Date: 12-Mar-2026
Our Ref: 2026/90110

**Discharge of details reserved by conditions 4 (materials), 11 (boundaries), 12 (bin storage) on previous permission 2024/93278 for erection of detached dwelling with parking area partly shared with other properties and associated external works
Adj, 497, Penistone Road, Shelley, Huddersfield, HD8 8HY
Application Number: 2026/90110**

client	MR I HELEINE		
project	NEW DWELLING LAND ADJACENT TO 497 PENISTONE ROAD SHELLEY, HUDDERSFIELD, HD8 8HY		
drawing	DETAILED SITE PLAN		
revision	notes	date	drawn
A	BIN STORAGE INCREASED	03.26	MG
scale :	1:50 AT A1	01.26	MG
project no.	drawing no.	revision	
2460	02	A

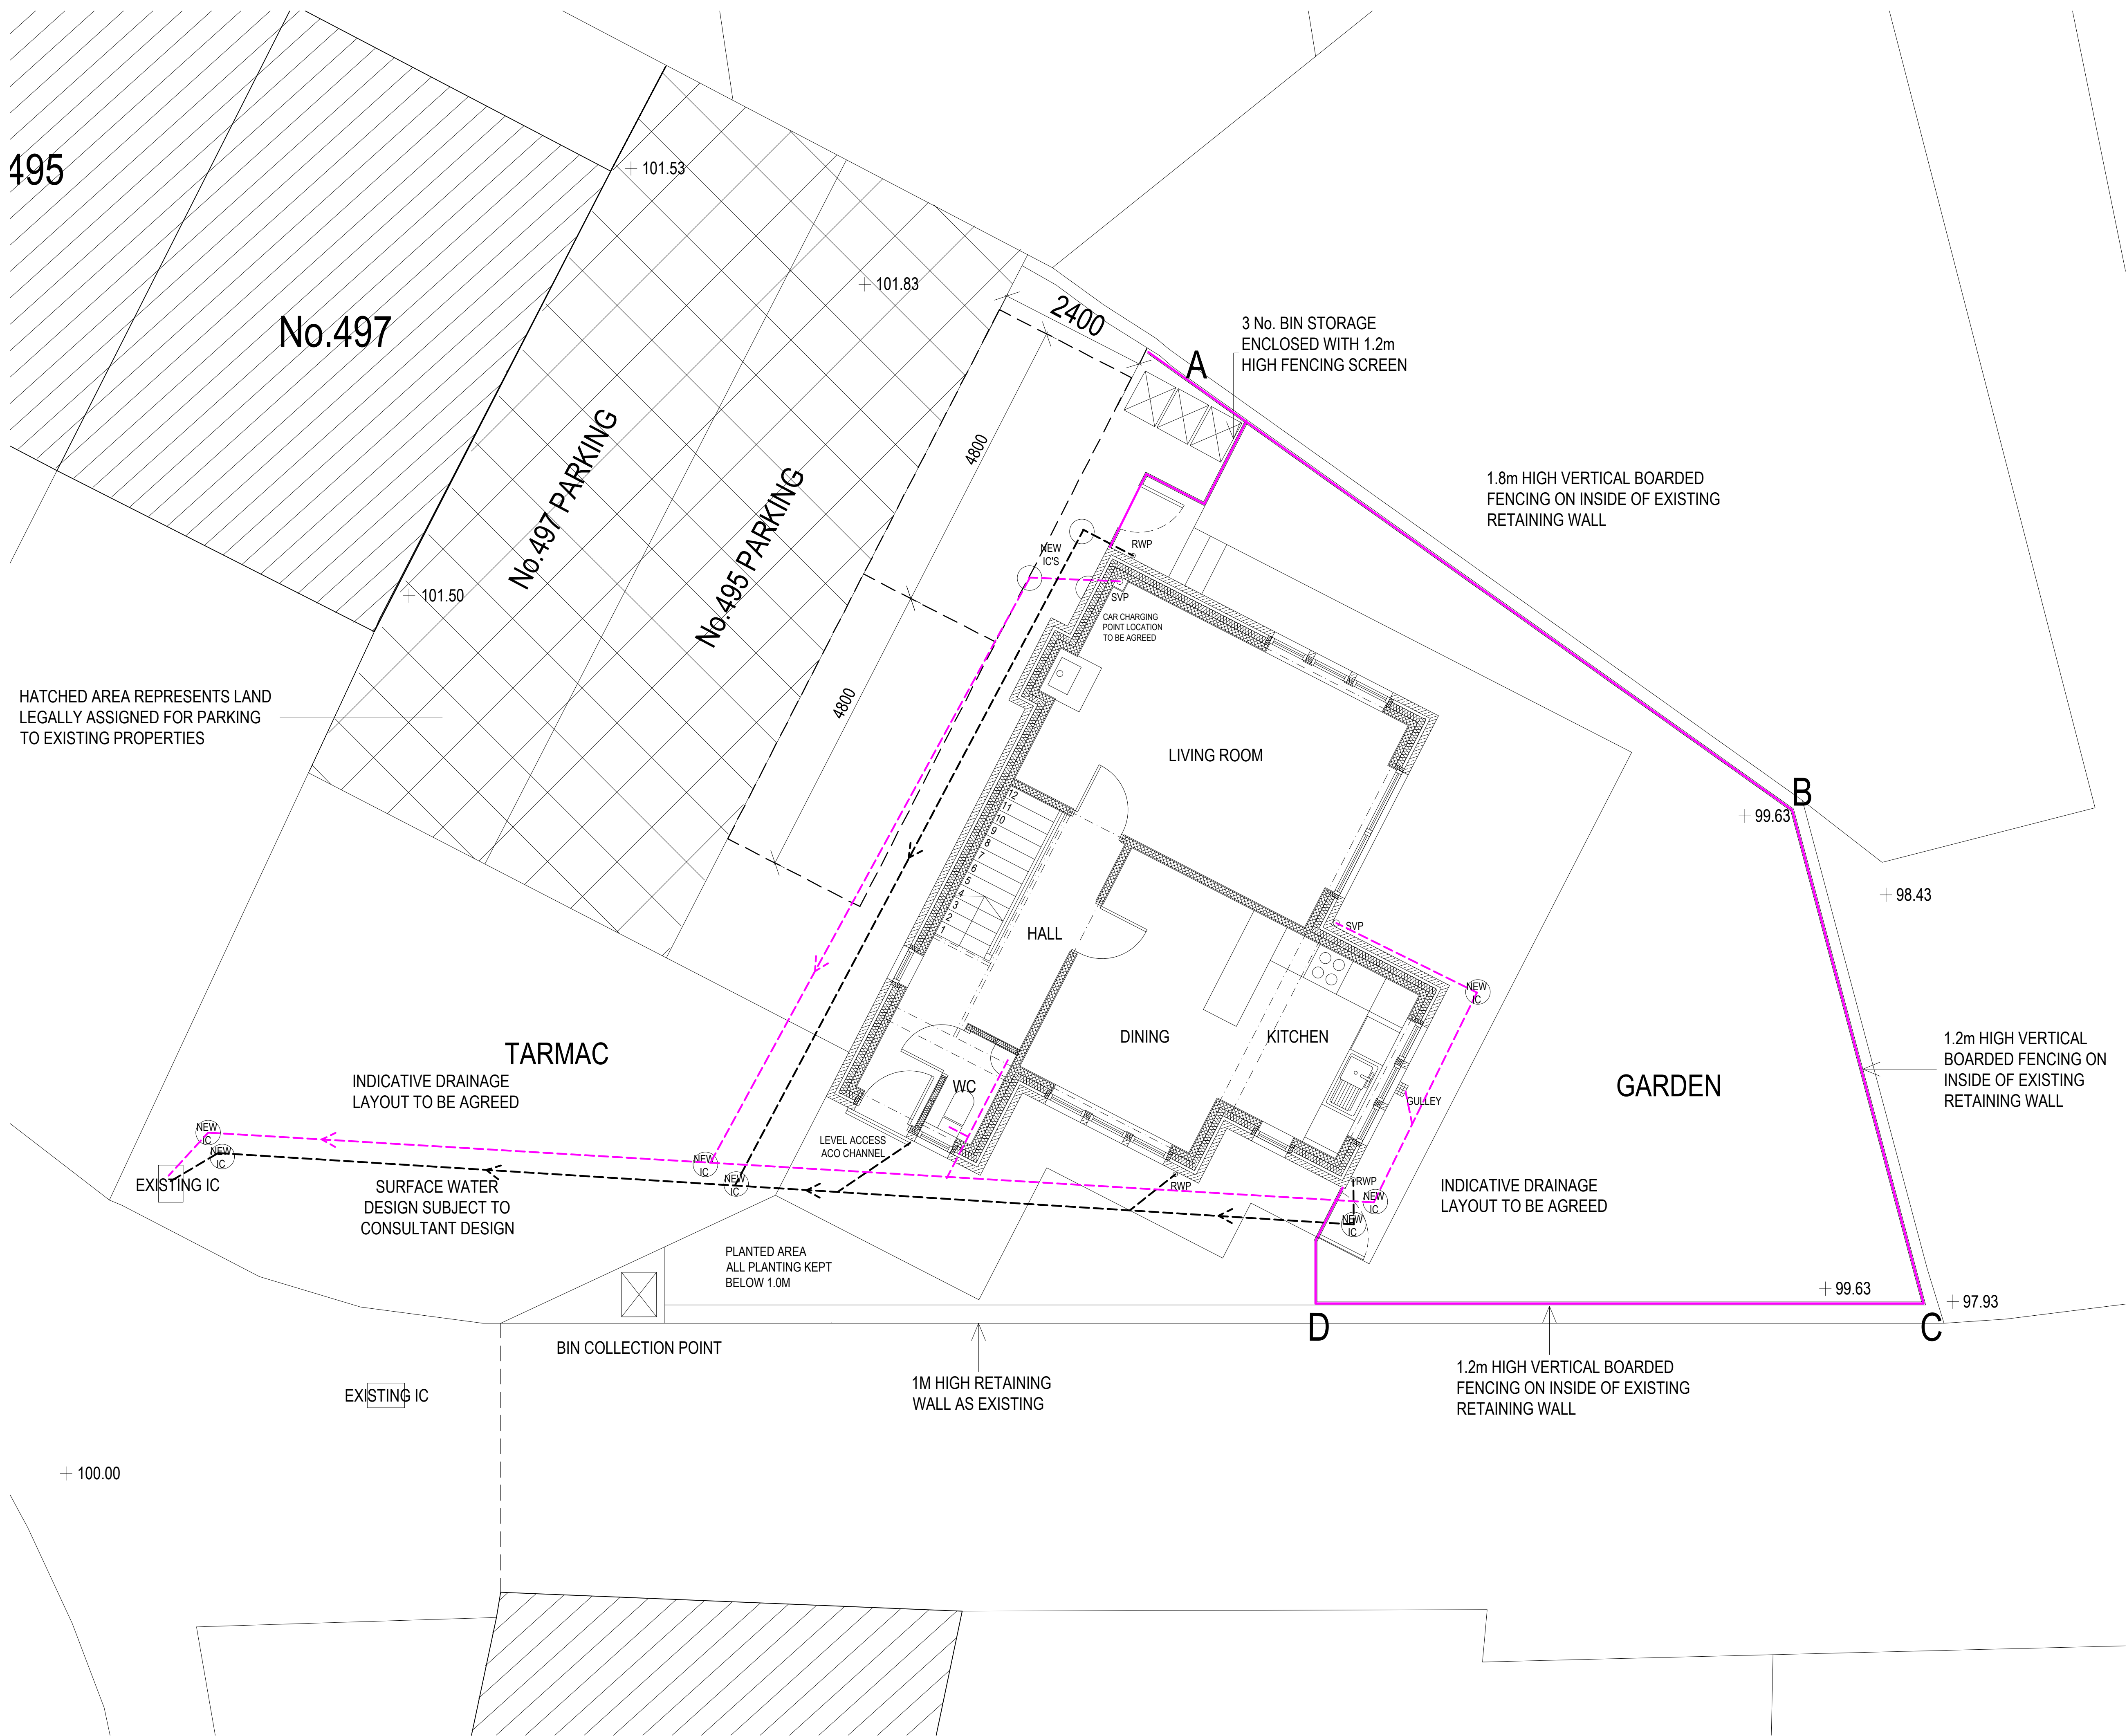
The details provided have been reviewed and considered acceptable for the purpose of condition 11. The development shall then be completed in accordance with the approved details before the dwelling is first brought into use and thereafter retained.

The details provided which demonstrate the location of bin storage and collection points on site. The plans have been reviewed with KC Highways and have been considered acceptable. The approved details shall be provided before first occupation and shall be so retained thereafter
